Application no: H16-0010-11

Description: Proposed signage

Location: 2 Pinchbeck Road
Spalding
Lincs
PE11 1QD

Amendment: Revision showing new signage to be sign written upon
20mm Marine Ply (dwg. no. 1043-01-A)

Scale 1:50 1:20 1:10 1:2.5	Drawing No. 1043-01-A
Date. JAN. '11	Drawn. J.C.

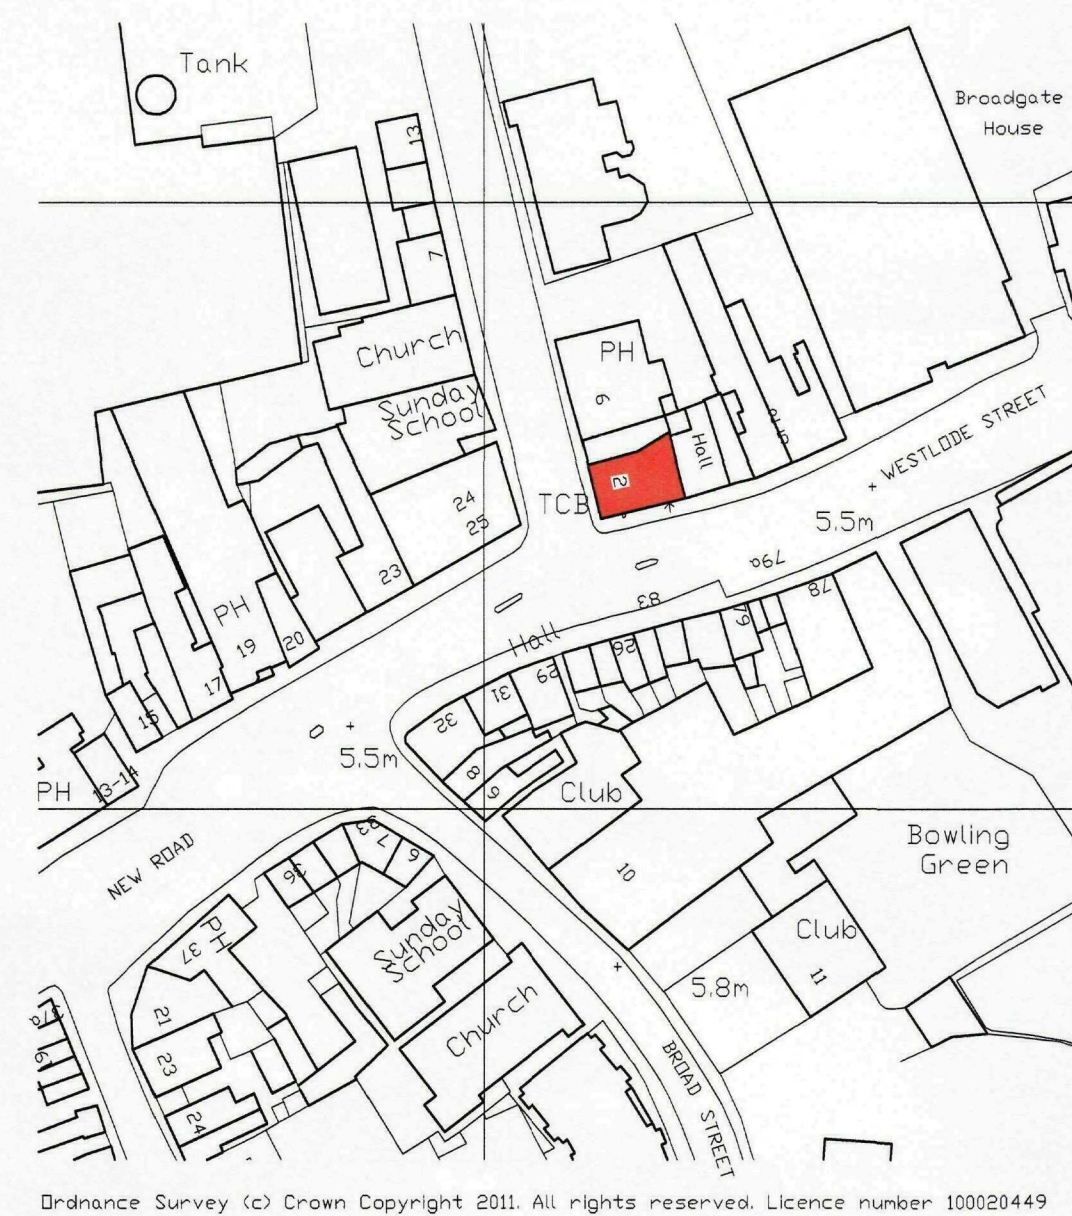
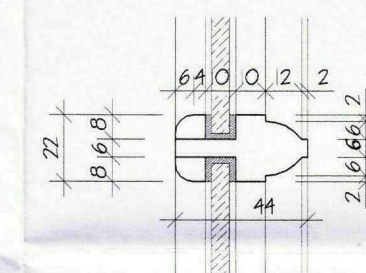
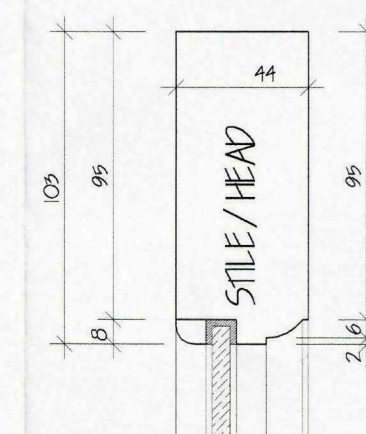
Please find enclosed revised plans which now show that all of the new signage will be sign
written upon painted 20mm Marine Ply in lieu of Perspex.

We would also confirm that the signs will not be illuminated, other than the spot lights to the
Hanging Sign and the existing illuminated Menu Box.
